PLANNING CONSULTATION RESPONSE

Application No	2025/0610
Proposal	Outline development of five residential dwellings and associated infrastructure considering access and scale.
Address	Vernon House, Yews Lane, Kendray, Barnsley, S70 3LJ
Date of Consultation Reply	16 th October 2025
Consultee	Highways DC

[2nd Response – Amended plans]

Visibility splays and proposed access arrangements

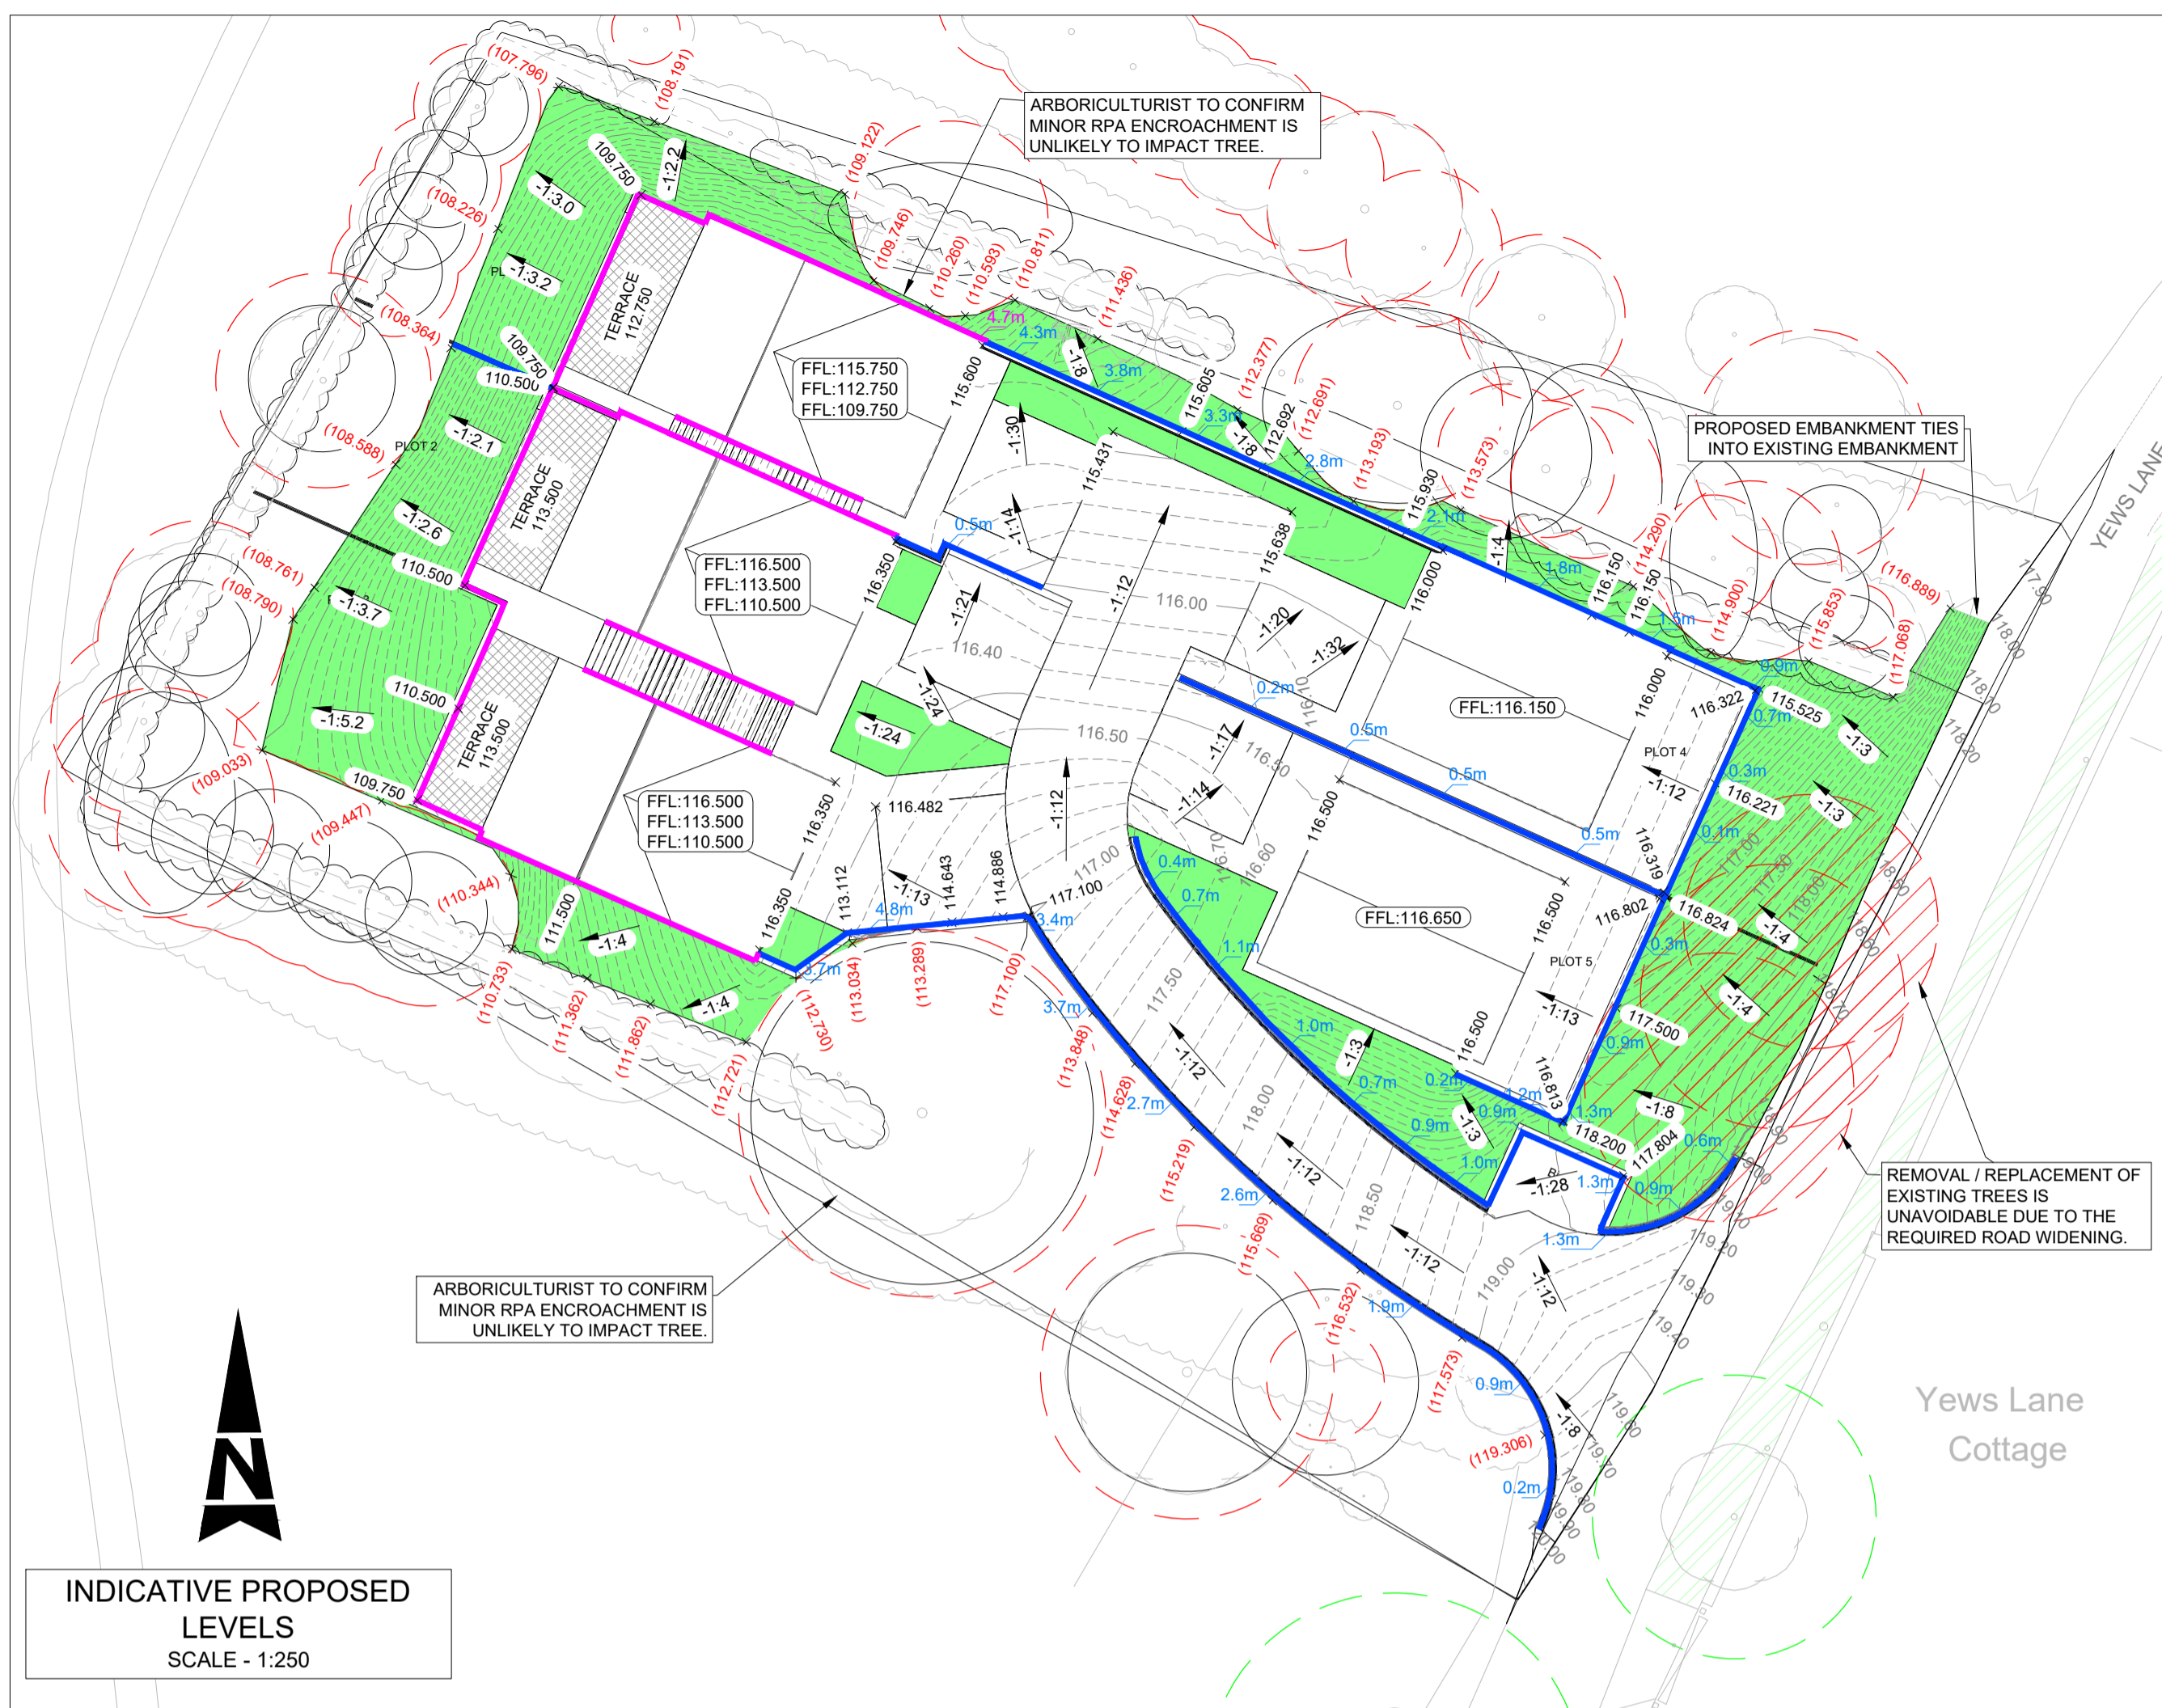
The submitted Technical Note includes a plan which now shows the visibility splays correctly drawn, the plan also indicates the extents of the adopted highway and the position of the site boundary. It would appear that the required sight lines of 2.4m x 34m to the left (North) and 2.4m x 32m to the right (South) are achievable from the proposed site access junction without encroaching onto third party land.

Sight lines, as shown on the submitted plans, shall be provided at the access junction with Yews Lane, such that there is no obstruction to visibility at a height exceeding 0.9m above the nearside edge of the adjacent highway. Nothing shall be erected, retained, planted and/or allowed to grow at or above a height of 0.9m which would obstruct the sight lines, and they shall be maintained free of obstruction at all times thereafter for the lifetime of the development.
